CITY OF ALBUQUERQUE

February 14, 2019

**Re: Car wash Vacuum
500 Coors Blvd. NW
30-Day Temporary Certificate of Occupancy- Traffic Certification Only
Transportation Development Final Inspection**
Engineer's/Architect's Stamp dated 12-15-18 (J10D041)
Certification dated 02-08-2019

SITE PLAN

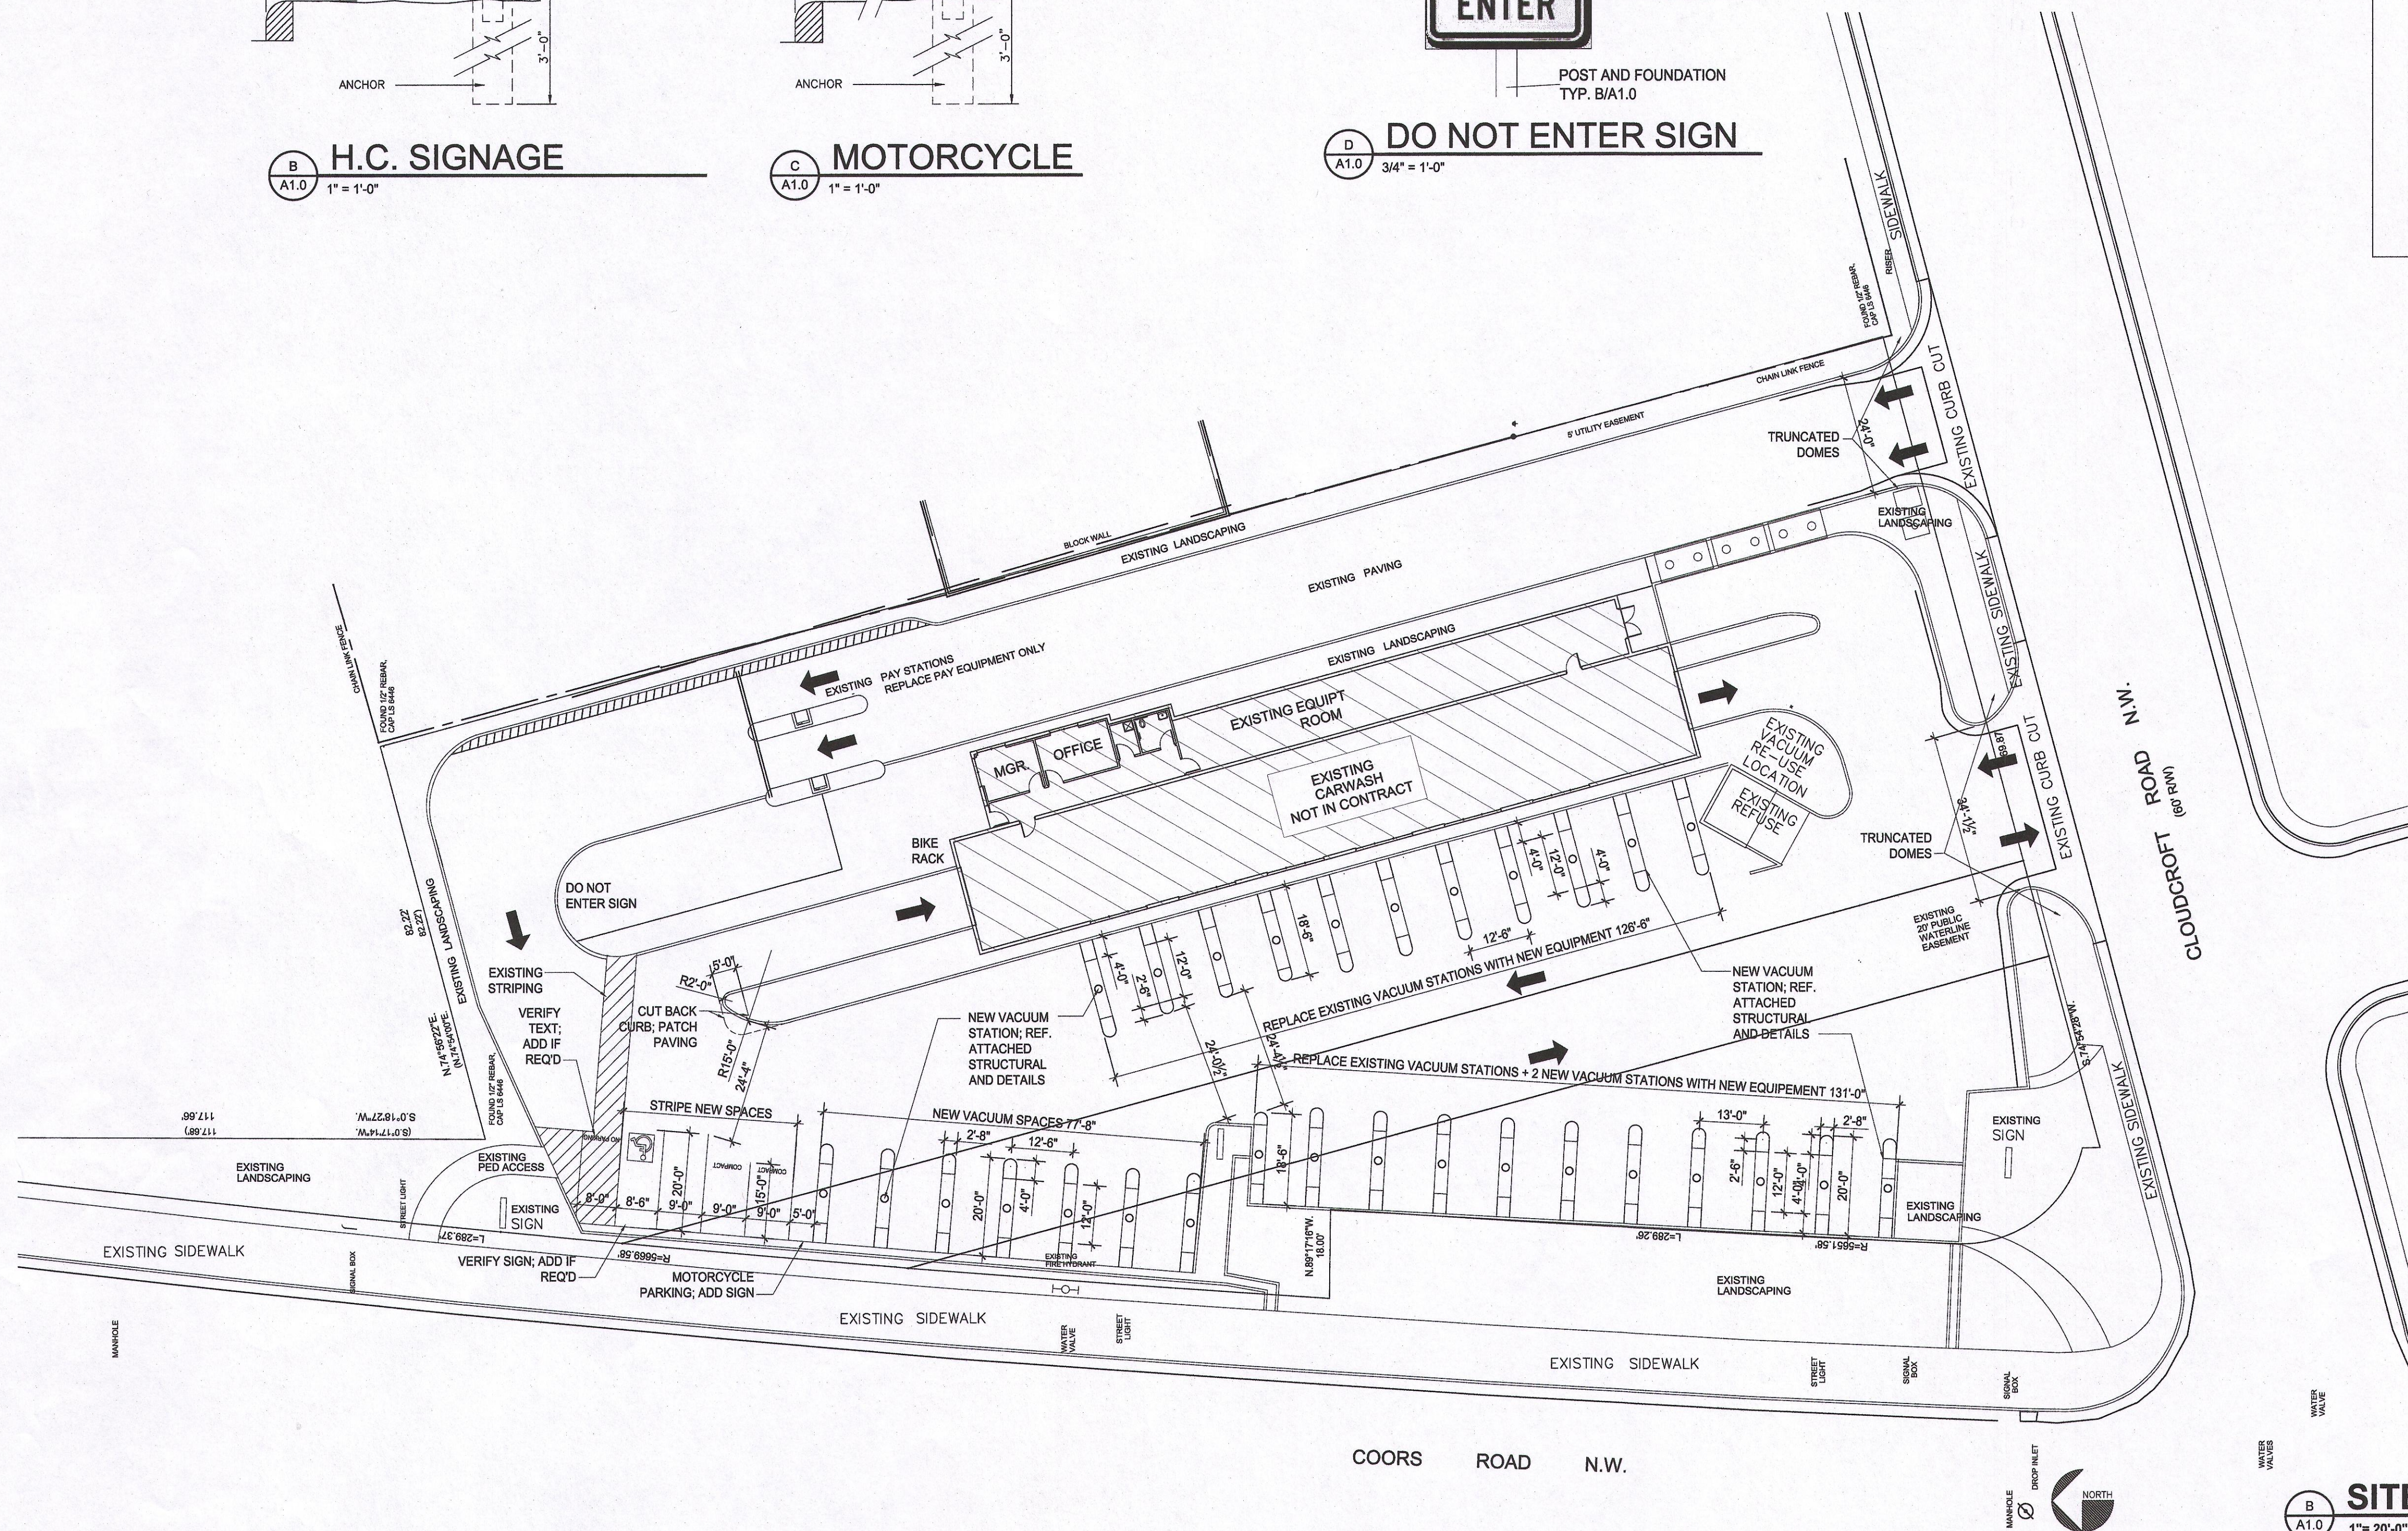
1. Please remove the fence.
2. Please send photos of corrections to PLNDRS@cabq.gov when requesting Final CO.
